# STEVE HOLD CONSULTING CIVIL ENGINEERING

## Removal of a Partition Wall at St. Andrews Llandaff.

This is a brief "letter style" report to cover my site assessment on the 15th December 2023 of the structural implications of removing the partition wall between the kitchen and the dining room at St. Andrews, Llandaff as indicated in my sketch SK/1.

PROJECT: REMOVAL OF PARTITION WALL IN ST ANDREWS LLANDAFF.
OBJECTIVE: FURTHER INVESTIGATION AND NEW CEILING SUPPORT CONCEPT.

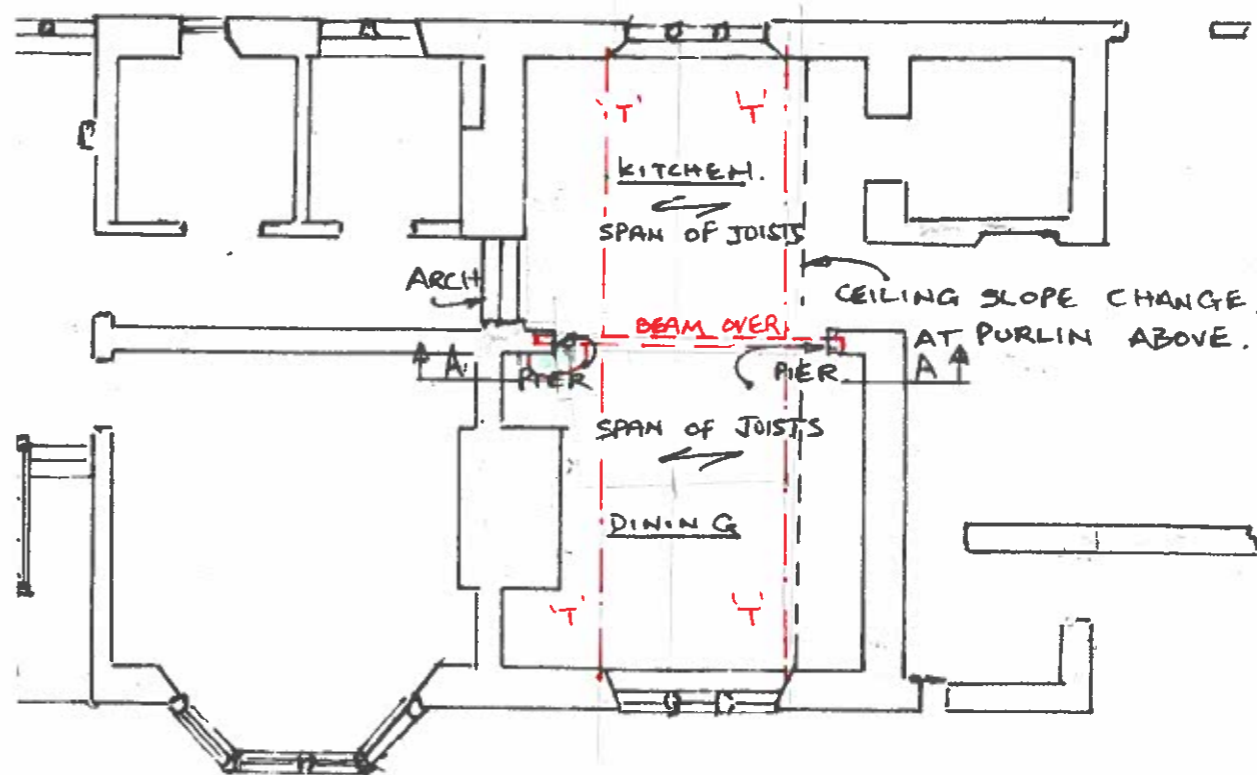
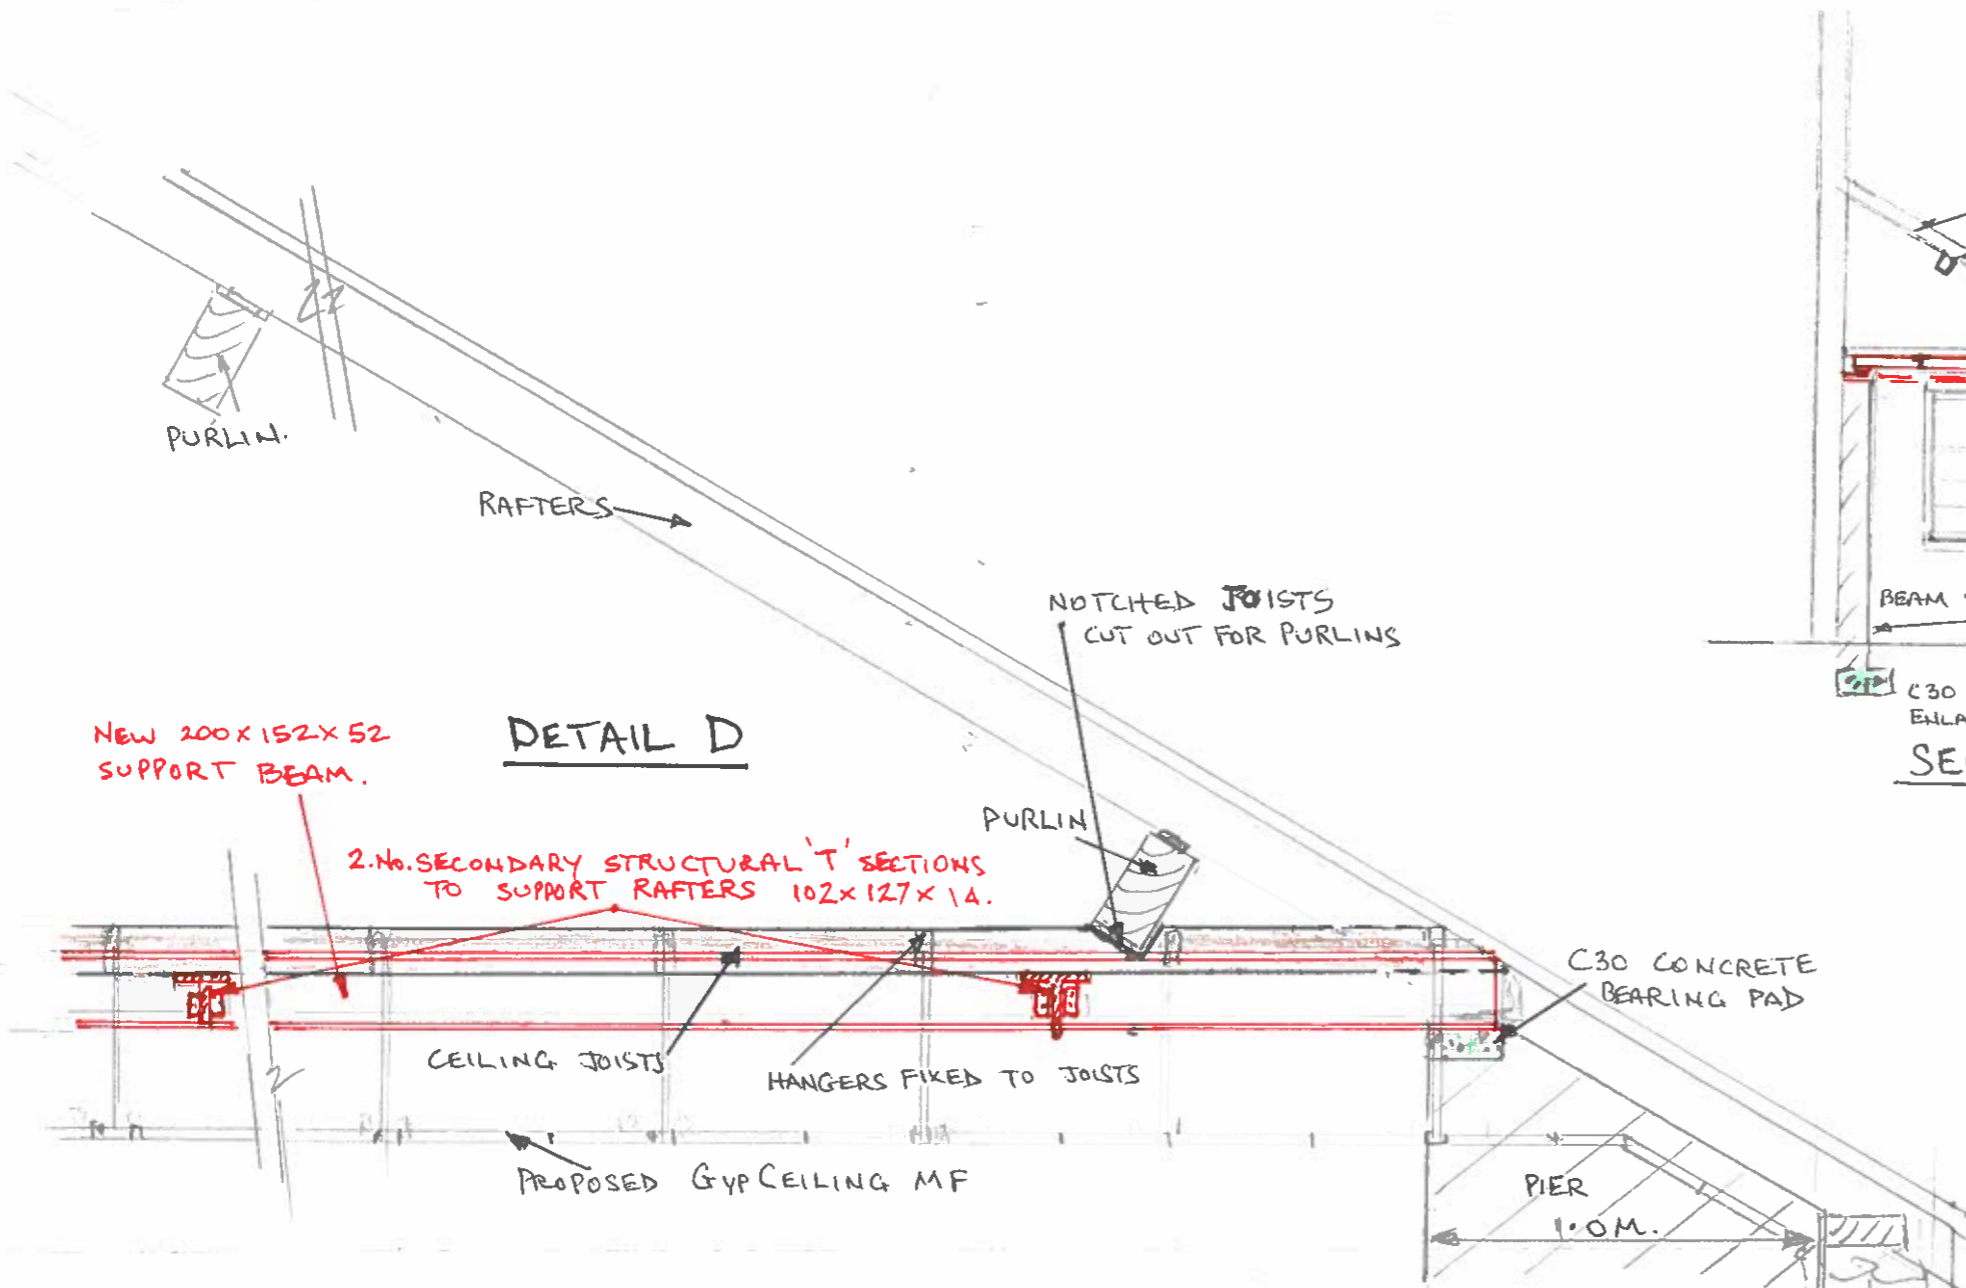
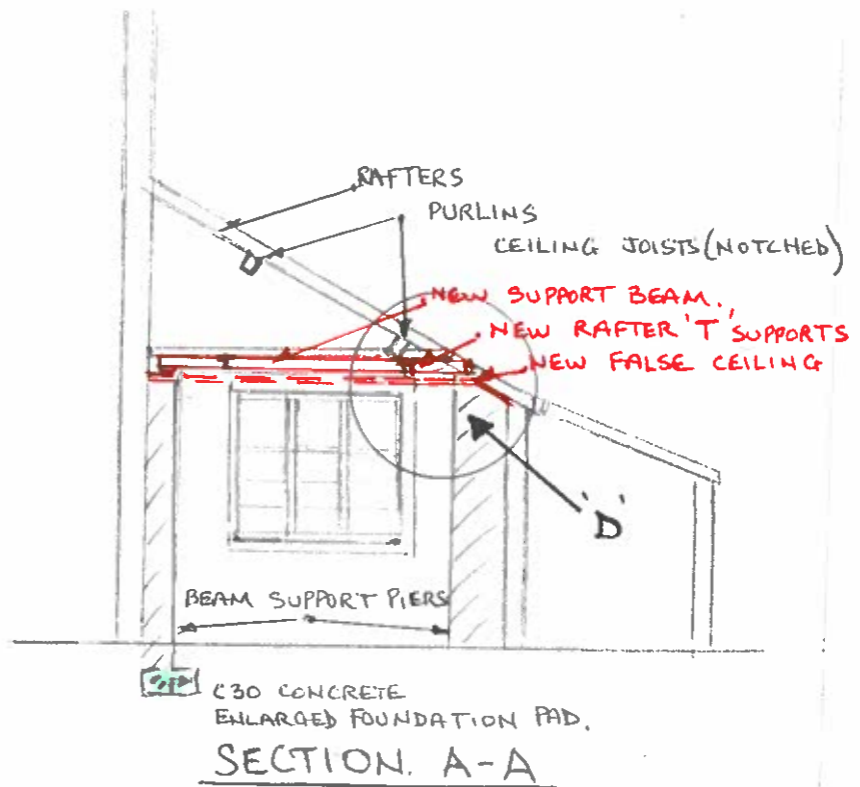
It can be seen that the span of the ceiling joists are parallel to the top of the masonry partition wall in Fig 3. This means that the load from the lath and plaster ceiling is not bearing on this wall and no replacement support beam will be required as the load paths are not changing.

The lath and plaster ceiling arrangement however does require structural consideration to check that the bearing support is sufficient at the external wall where the ceiling has been given an increased pitch from the horizontal beneath the 30 degree pitch of the roof above to more like 45 degrees and is currently obscured and therefore needs to be investigated. Figs 4 and 6. This is because some of the ceiling joists have also been replaced or cut and spliced and the joists spanning onto the external wall have been "notched out" around the lower purlin close to the wall and this may have weakened them. The replacement timbers indicate that either rot or wood worm were found during the roof replacement and could be replaced in the visible accessed areas but these defects may still be present behind the obscured 45 degree pitch ceiling. The evidence of the new timbers that were needed is shown in Fig 2.

The fragility of the lath and plaster ceiling requires care when removing the masonry between the two ceiling joists at ceiling level and thought needs to be given to the making good of this strip of ceiling. Fig 3.

My conclusions are that this partition wall can be removed but that some masonry is left in place at either end of the wall to provide additional ceiling support as shown in SK/1.
